VANTAGE WIND POWER PROJECT

**Applicant response to Comments received
and SEPA**

SUBJECT: Vantage Wind Power Project – Notice of Application

Response: Washington Department of Natural Resources (November 20, 2007 Letter of Comment)

Figure 6. Habitat and hedgehog cactus (*Pediocactus simpsonii*) populations for the proposed Vantage Wind Project development area.

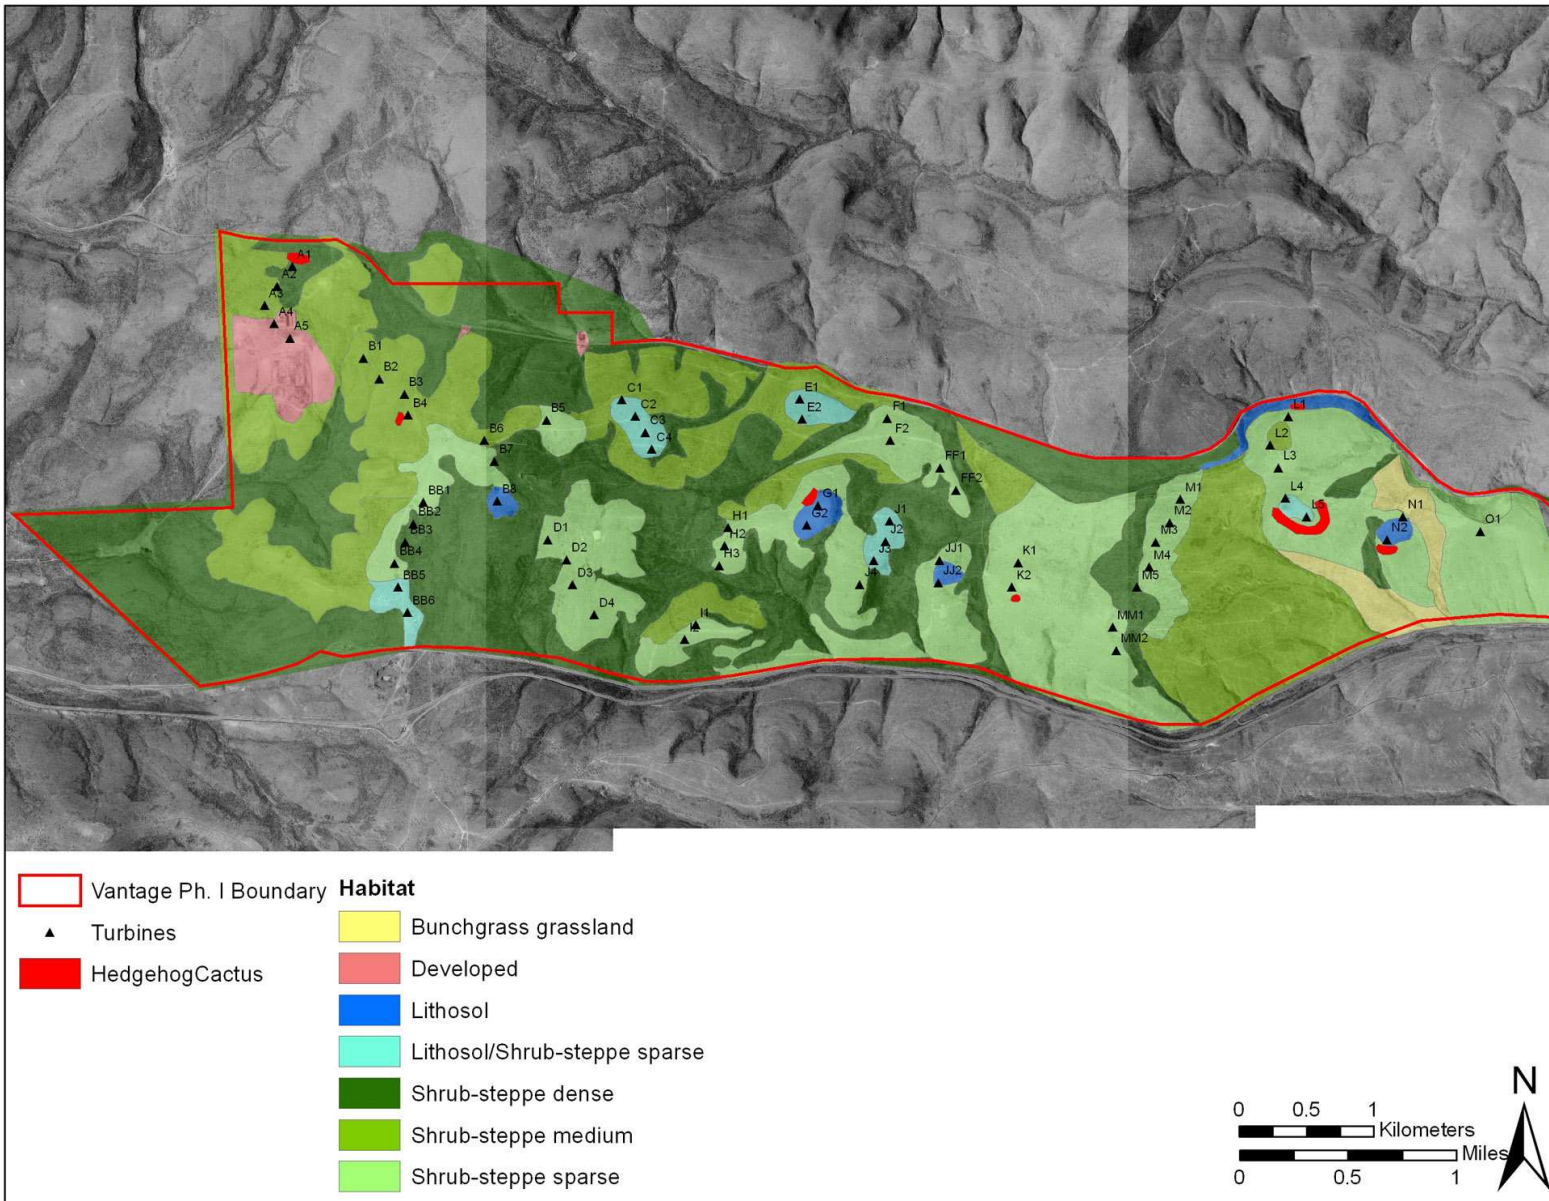
Comment No. 4: "Another concern is the relocation of hedgehog cactus (*Pediocactus nigrispinus*), also known as snowball cactus, as mitigation. Relocation of individual hedgehog cactus plants has been successful at the Wild Horse Wind Power Project, but generally the transplanting of native plant species is not successful. The Natural Heritage Program does not support the relocation of rare plant species as an adequate mitigation measure."

Response to Comment No. 4: Comment noted. The hedgehog cactus will be avoided wherever possible. The plants will be field-flagged to allow for micro-siting of the towers and other facilities during the project design phase.
